# MONA OFFSHORE WIND PROJECT

## Mona Change Request Report

Document Reference: S\_CR\_2

15 November 2024

Extract from Works Plans – Onshore (AS-003)

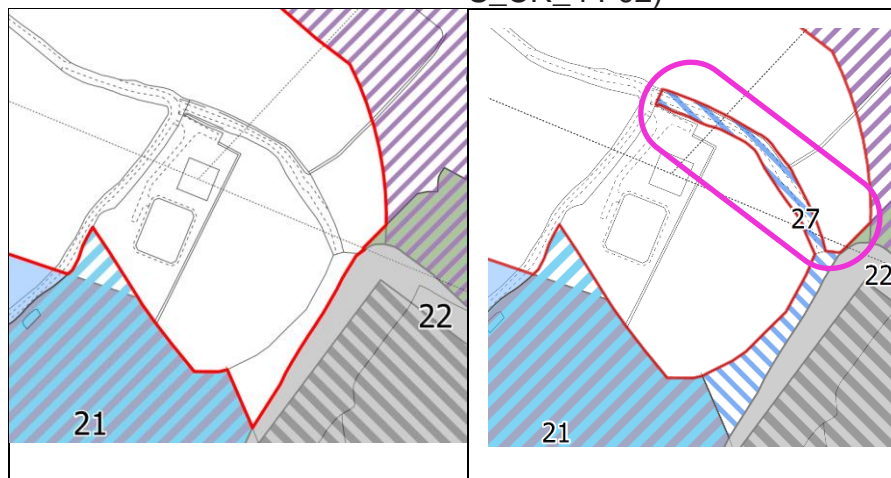
1.2.1.2 This change will result in the inclusion of a section of the existing access track at the onshore substation at grid reference SJ 01353 73277 within the Order Limits to accommodate temporary access.

1.2.1.3 This existing access track is currently being utilised by the Applicant for ongoing site survey and investigation works. This change does not involve any works or upgrades to the existing track, the track will only be used to take access to Work Nos. 21, 22 and 33 (and other works areas through Work Nos. 21, 22 and 33).

1.2.1.4 As shown on the Change Request: Works Plan - Onshore (Document Reference S\_CR\_4 F02), Change 1a will become part of Work No. 27.

Extract from Works Plans – Onshore (AS-003)

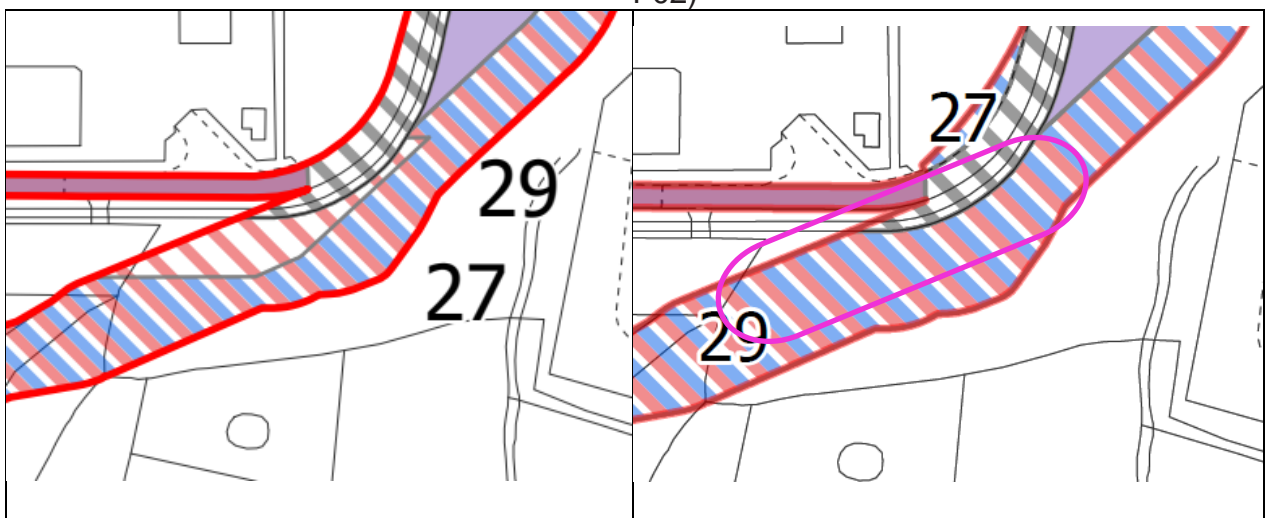
**Change 2b – Amendment to Work No. 27 to widen the temporary onshore substation construction access road at grid reference SJ 01906 735519 by including a small area of additional land to the area identified for Work No. 27 (approximately 538m<sup>2</sup>) within the existing Order Limits. This land is currently identified as part of the permanent onshore substation access (Work No. 29) only.**

1.2.2.4 The Applicant’s preliminary design work has identified additional space is needed along the temporary construction access road in this area to facilitate the AIL’s whilst ensuring adequate space for the fencing requirements outlined in the Outline Fencing Management Plan (REP2-048).

Extract from Change Request: Works Plan - Onshore (Document Reference S_CR_4 F02)

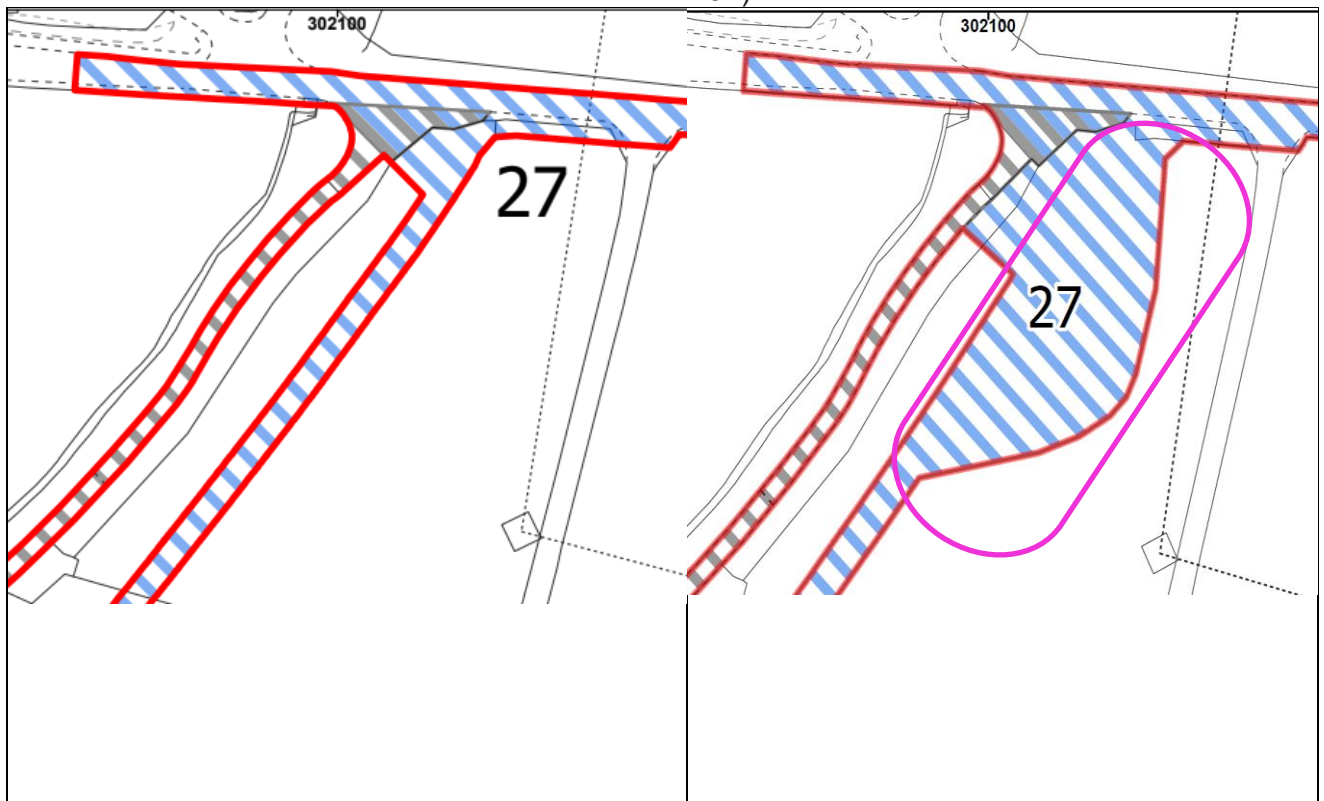
1.2.3.1 This change results in a widened temporary onshore substation construction access road (eastward) to accommodate an additional temporary Sustainable Urban Drainage System (SuDS) attenuation pond at the northern extent of the onshore substation construction access road.

1.2.3.2 The additional area of land required for Change 3 amounts to approximately 2350m<sup>2</sup>. Whilst this land was included within the Mona PEIR Offshore Wind Project Boundary published in April 2023, it was not included upon submission on the basis of the preliminary designs for the onshore substation construction access road. However, the Applicant’s early detailed design works for the onshore substation construction access road, including the swept path analysis outlined in Change 2 (specifically Change 2a), have identified the need for additional land take. This is in order to deliver attenuation to control the discharge of surface water during construction, in part due to the wider road outlined in Change 2a, and also from the requirement for great crested newt fencing to be deployed, likely resulting in additional drainage pathways. It is proposed to construct a temporary SuDS attenuation basin as a measure to control this additional surface water runoff. The proposed Change 3 will result in

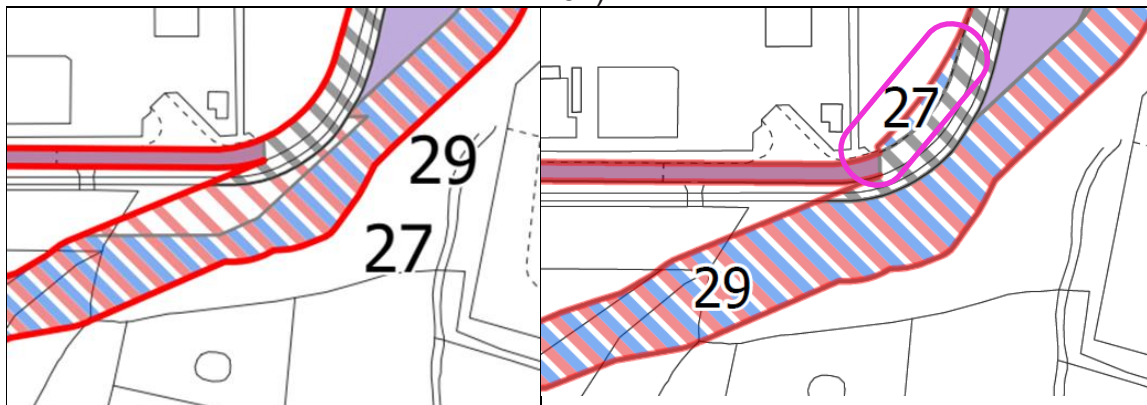
1.2.4.1 This change results in an extension of the Order Limits at grid reference SJ 01935 73551 to include the site of proposed Change 4. Proposed Change 4 will comprise a temporary area of hardstanding to be constructed immediately to the north of the existing road providing access to Bodelwyddan National Grid Substation and Gwynt y Mor Offshore Transmission Operator substation. This hardstanding will be in place during the construction period only and is necessary to facilitate the establishment of the permanent access road (Work No. 29).

1.2.4.2 In providing this temporary hardstanding, disruption to the users of the existing road will be reduced by removing the need to temporarily close the road for construction purposes.

1.2.4.3 The additional area of land required for Change 4 amounts to approximately 126m<sup>2</sup>. Whilst the land required for proposed Change 4 was included within the Mona PEIR Offshore Wind Project Boundary published in April 2023, it was not included upon submission on the basis of the preliminary designs for the onshore substation area. As with the other changes set out above, the need for the extension to the Order Limits at this location has subsequently arisen as a result of the Applicant’s early detailed design works and as a consequence of ongoing landowner engagement. The landowner has expressed a preference to implement the permanent access road at the furthest possible point along the alignment of the existing access road and this change is necessary to facilitate that option. For the avoidance of doubt, despite this proposed Change 4, the Applicant needs to retain the access route optionality in this area (as shown on sheet 11 of Works Plans – Onshore (AS-003)) due to the complex nature of the constraints within these areas – utilities (including a high pressure gas main), drainage infrastructure, export cables, desire for continuity of access over the existing road, amongst others. The preferred option will be selected during the detailed design process.
